SABIC UK PETROCHEMICALS LIMITED AND SABIC PETROCHEMICALS BV (URN 20053908)

THE MORGAN OFFSHORE WIND PROJECT AND MORECAMBE OFFSHORE WINDFARM: TRANSMISSION ASSETS DEVELOPMENT CONSENT ORDER (EN020028)

SABIC'S REPLY TO APPLICANTS' RESPONSE TO ITS WRITTEN REPRESENTATION

Figure 1-1: Environmental mitigation areas at south of Newton-with-Scales

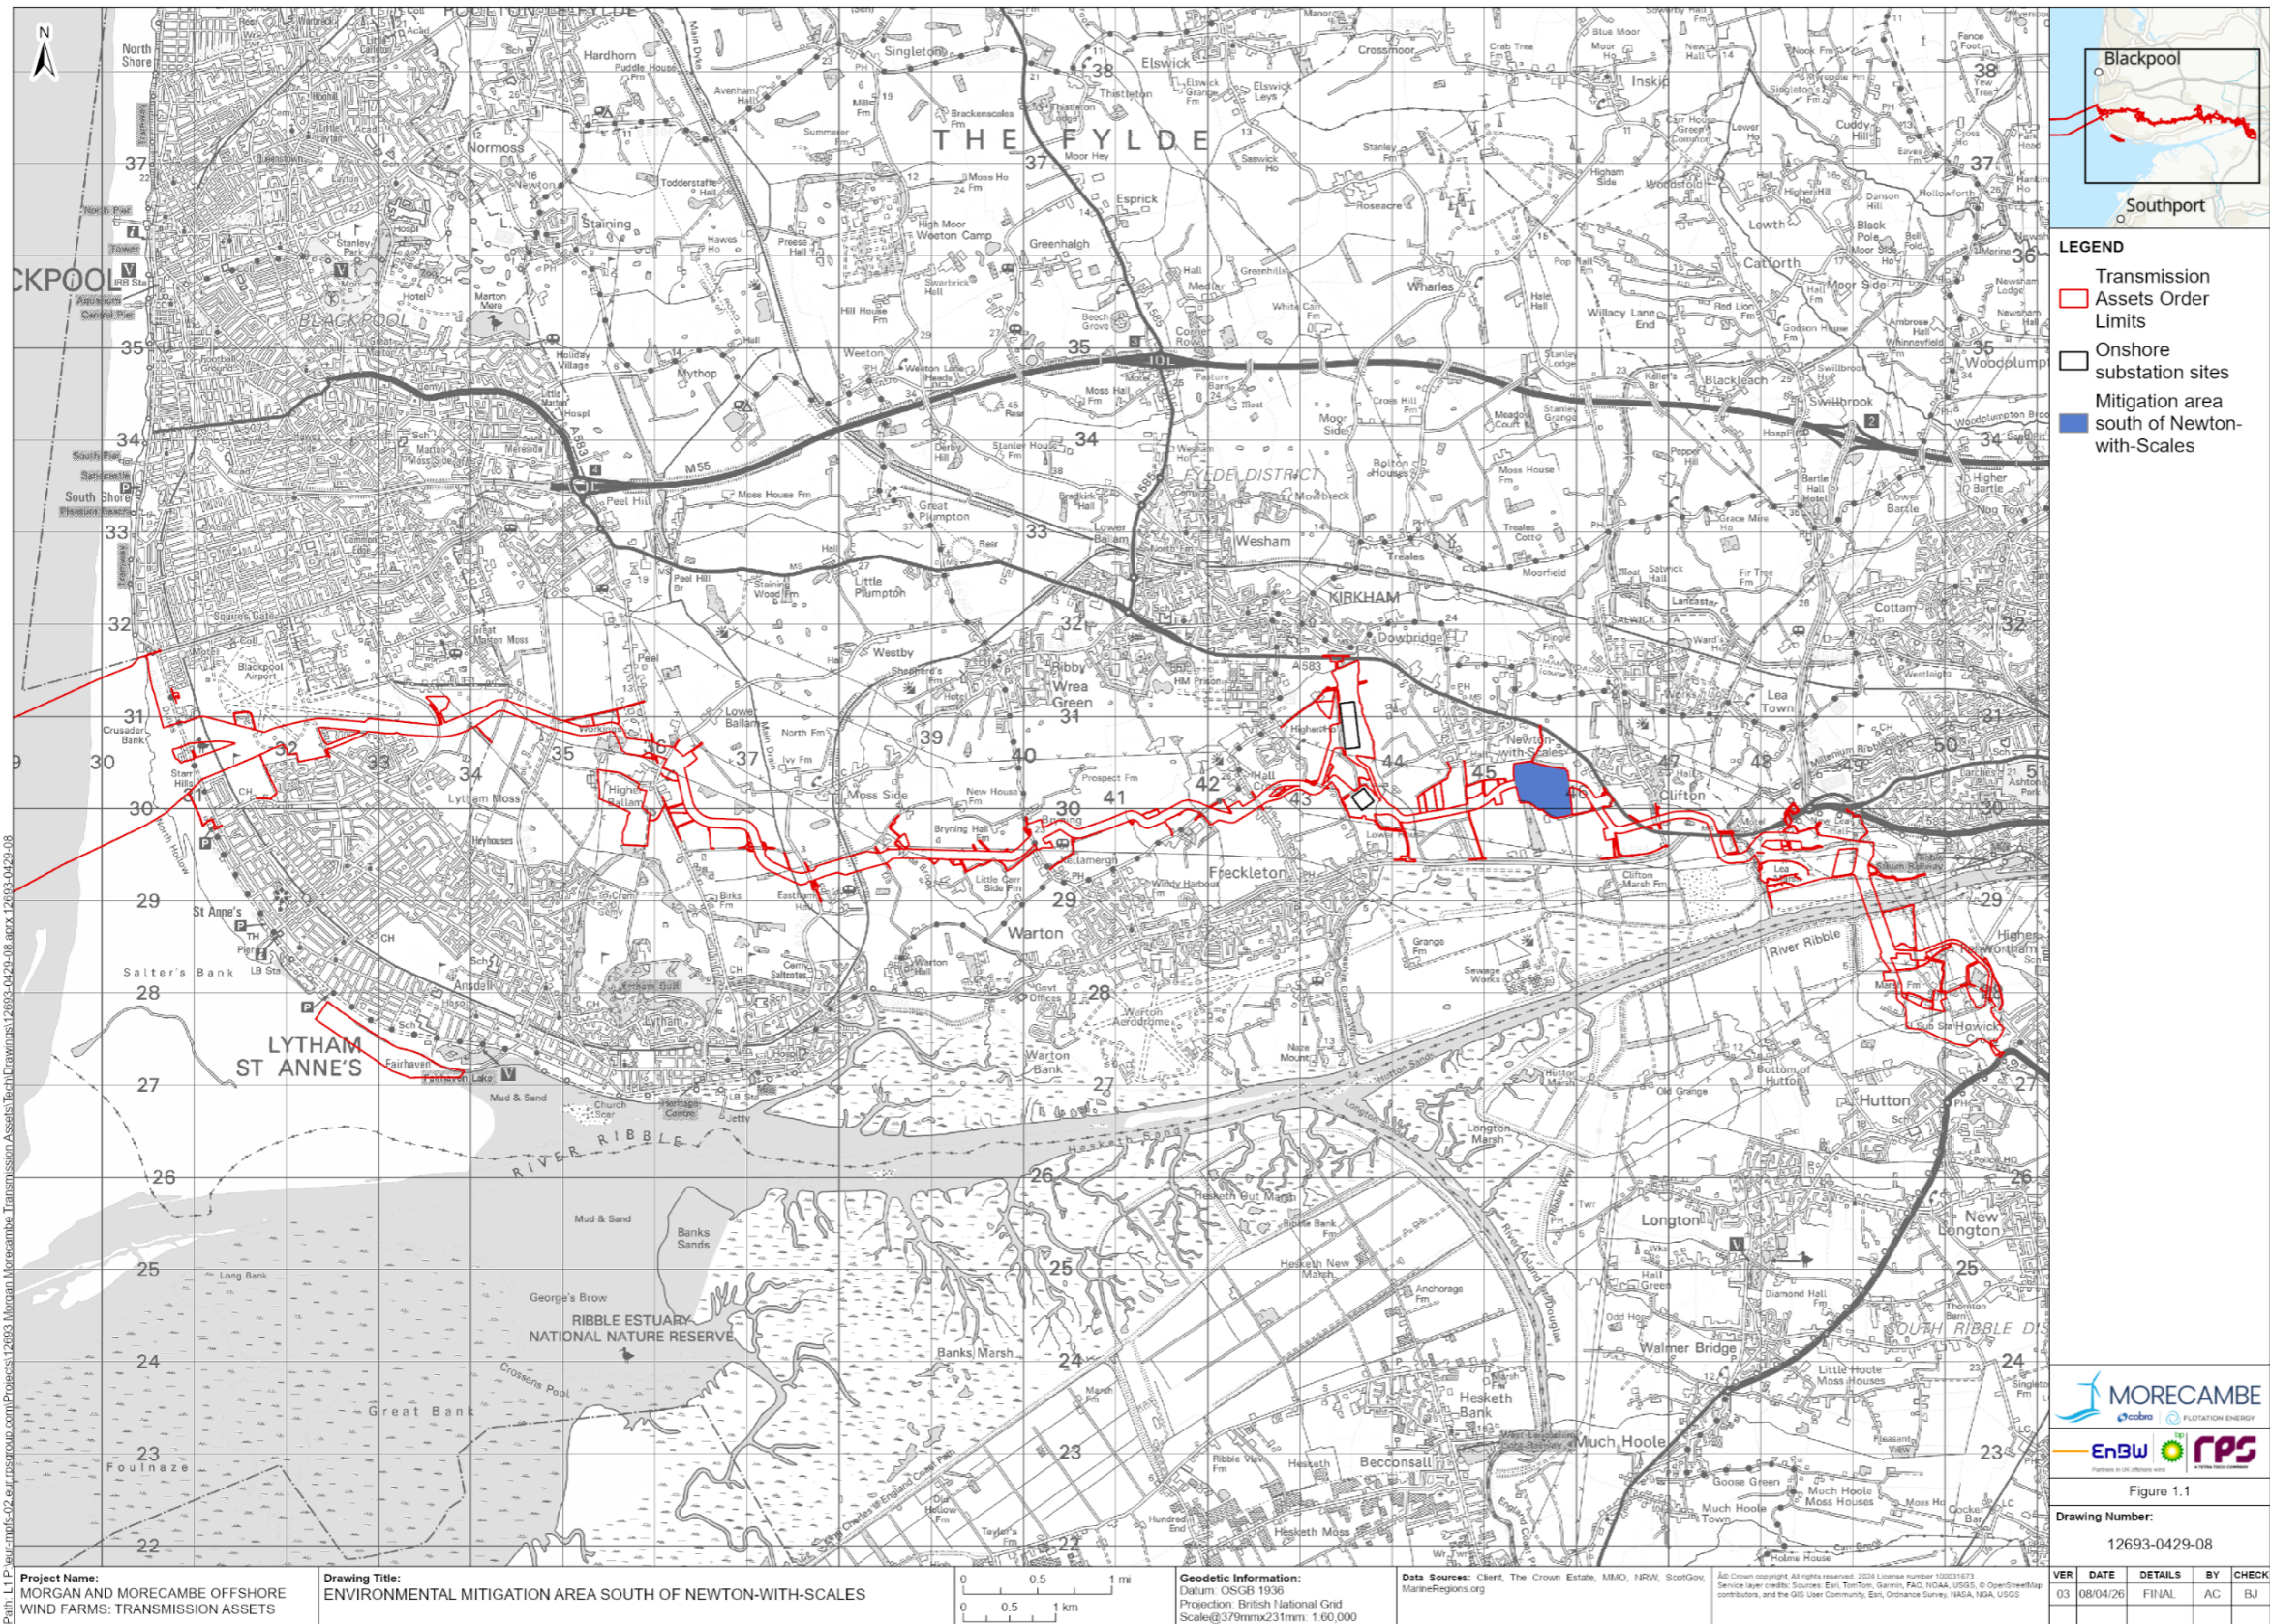
REP1-195 195.7	<p>5.2 Permanent Environmental Mitigation Works</p> <p>5.2.1 The dDCO provides for Works Nos. 49A and 49B as "permanent environmental mitigation works" over a 30 hectare site. The works are identified in the Outline Ecological Management Plan ("OEMP") as "Permanent mitigation area south of Newton-with-Scales".</p> <p>5.2.2 SABIC has two concerns about the scheme in this location:</p> <p>(a) The proposed wader scrapes (shallow depressions created in fields to benefit wading birds). The making of these depressions by the Application would be of concern to SABIC if they are in the vicinity of the TPEP, as they would constitute excavations which could damage the TPEP. Additionally, any loss of cover above a pipeline increases the risk of third party interference with it.</p> <p>(b) The thickening of existing hedgerows and gapping of hedgerows with new native planting. SABIC maintains certain rules in relation to planting of trees and shrubs in the vicinity of the TPEP, as their roots would be likely to</p>	<p>The Applicants note SABIC's concerns regarding the proposed permanent environmental mitigation works in the vicinity of the TPEP. As noted in the Applicants' response to SABIC's relevant representation (Table 2.103 of PDA-007), the detailed design of the measures at the permanent mitigation area south of Newton-with Scales will take into account SABIC's TPEP infrastructure.</p> <p>Further, the Applicants refer to row 1917.5 in Table 2.103 of PDA-007, which sets out how the draft DCO (C1/F04)</p>	<p>The Applicants' response indicates that they will take into account SABIC's TPEP Infrastructure in the detailed design of the permanent mitigation area south of Newton-with Scales. SABIC's concern is that there is no formal mechanism in place to ensure that this takes place.</p> <p>Given the nature of its apparatus, and the reduction in soil cover which would result from a wader scrape, SABIC does not consider that it would be appropriate to install any part of the wader scrapes within 6 metres of any part of the TPEP to avoid the potential for erosion or land slip from that point to ingress towards the pipeline.</p> <p>It also considers that there should be an enforceable mechanism to ensure that the hedgerow planting accords with the restrictions set out in the below table:</p>

<p>cause damage. For example, hawthorn should be planted not less than 3 metres away from the TPEP.</p> <p>5.2.3 In light of these difficulties and constraints, SABIC does not believe that it is appropriate for the scheme to use this land and is very concerned that the Applicant has not given due consideration to possible alternatives.</p>	<p>controls the Applicants' compulsory acquisition and other powers in relation to apparatus or land owned by SABIC.</p> <p>As outlined above, the Applicants confirm that the protective provisions for the protection of pipelines, including the TPEP, are already included at Part 3 of Schedule 10 of the draft DCO (C1/F04). These provisions ensure the safety and integrity of pipeline infrastructure during the delivery of all Transmission Assets works, including environmental mitigation measures.</p> <p>The Applicants are reviewing the additional draft protective provisions submitted by SABIC and will continue to engage with SABIC to address its specific concerns, while ensuring the delivery of the Transmission Assets, including the environmental mitigation works, in accordance with detailed Ecological Management Plan(s), which will be informed by the Outline Ecological Management Plan (APP-212).</p>	DISTANCE FROM PIPELINE	SPECIES	MATURE HEIGHT
